Change of use of part of first floor from flat to restaurant. Single storey extension and roof re-modeling to rear - resubmission of LU/350/13
Waterfront 46 Pier Road Littlehampton West Sussex

Thank you for your internet representation made on 20th March 2014 which has been recorded as '**an objection**' with the comments as follows:

No:
1501/01/06/A

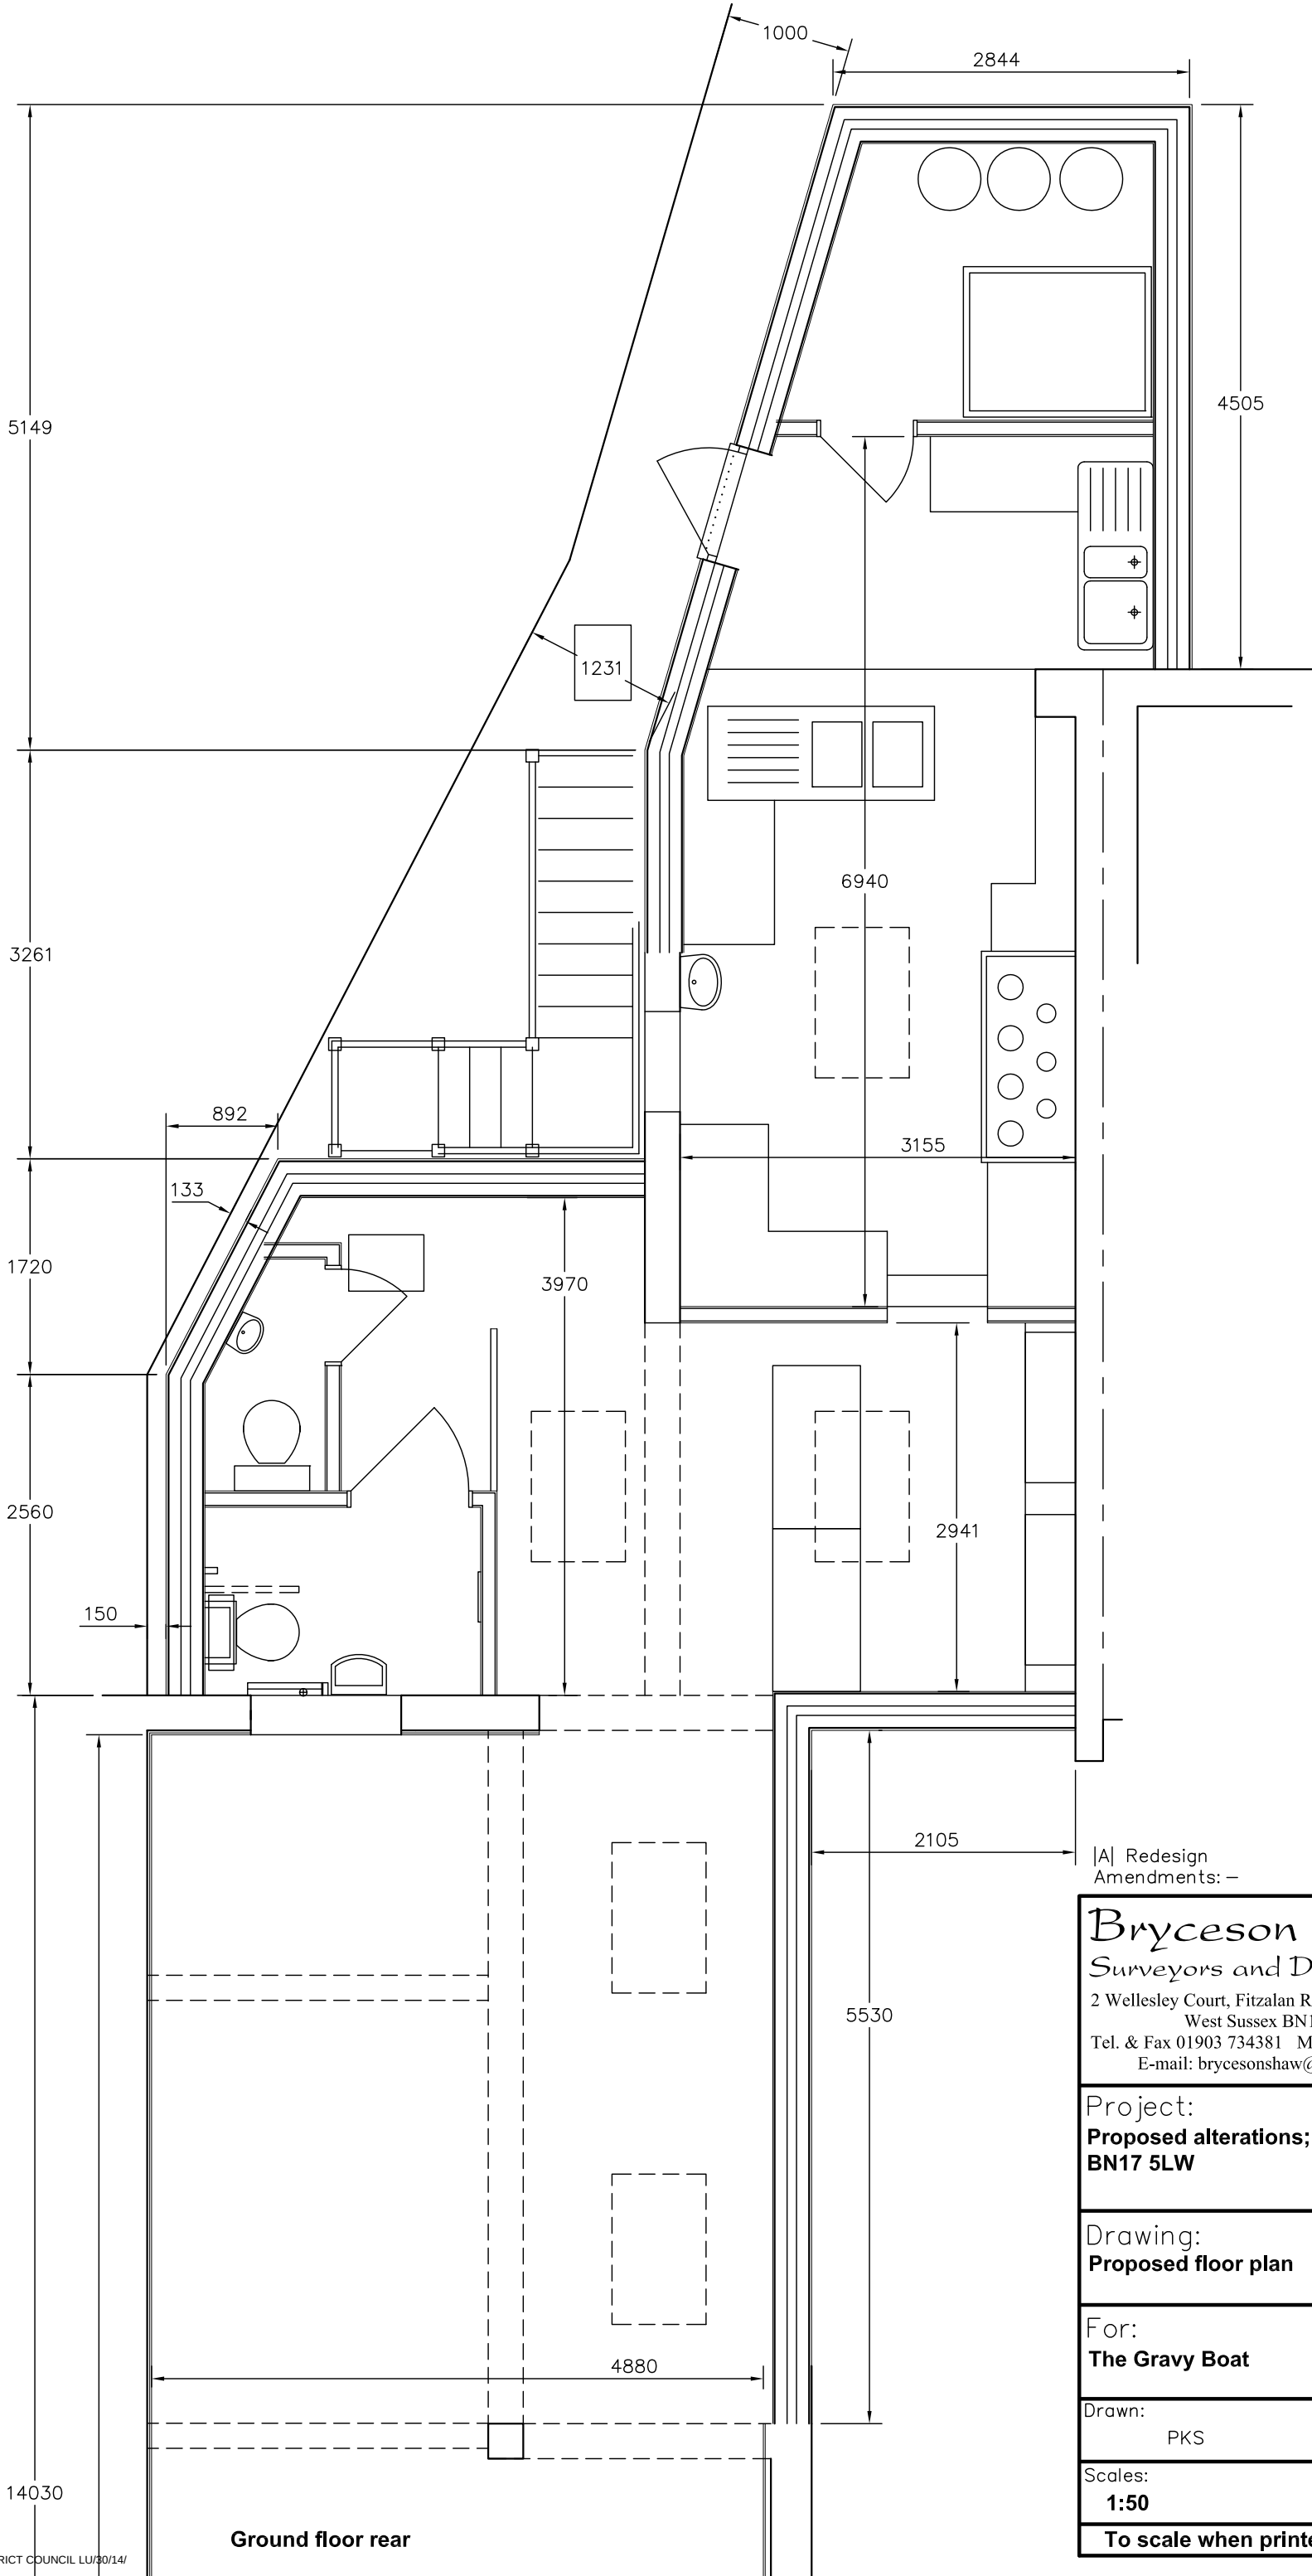
Although in principle we still have no obligations to the change of use, our fears are with the 1st floor living room being designated as a restaurant/ dining area with a dumb waiter. We are interpreting the drawings in as much that they show the dumb waiter and the staircase still being attached directly to the party wall.

As both of these elements will be adjacent to our living room and hallway, we are concerned about the associated noises permeating through the wall throughout the trading period, which will seriously impede our right to enjoyment of our abode.
